PLANNING AMENDMENT

H 13/0742/01/A1

NEW CONSERVATORY EXTENSION

Amendment: Traditional slate roof in lieu of glass
Dwg. received 16 November 2001

**DETERMINED
PLAN**

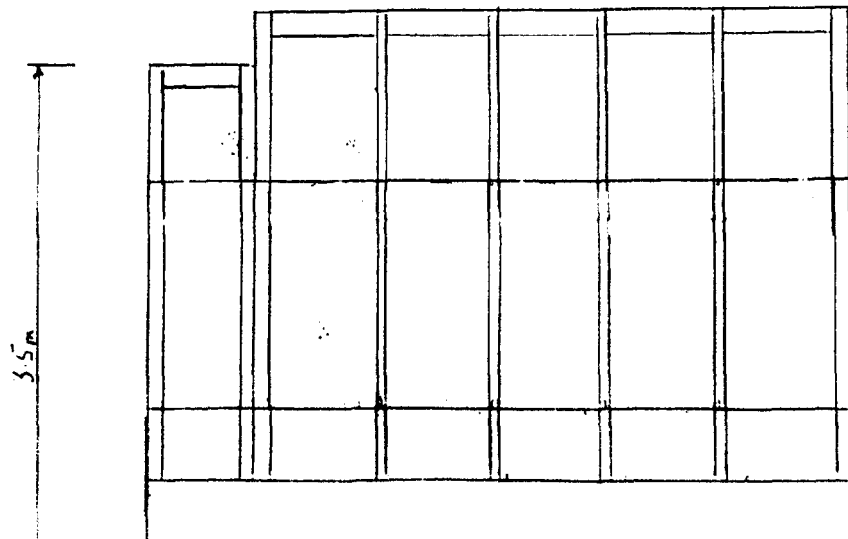
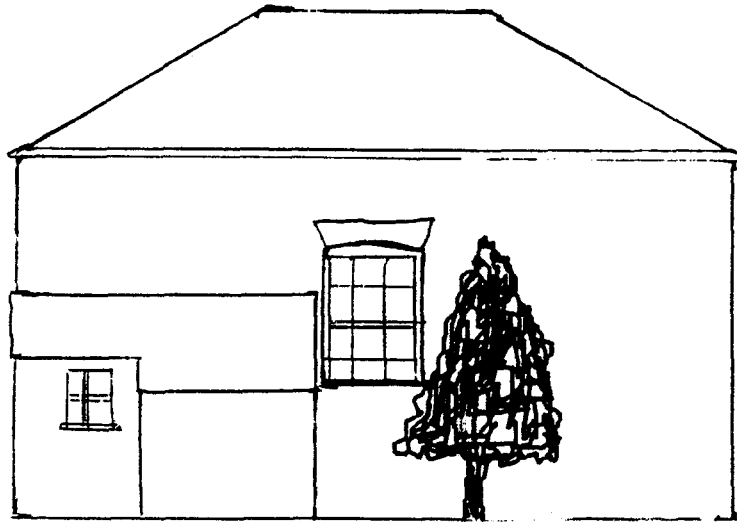
~~Sub~~ Traditional slate roof in
lieu of glass.

Roof to be finished with traditional
re-claimed slates. Fascia to be
25mm x 150mm timber to which
100mm black half round gutter is to be fitted.
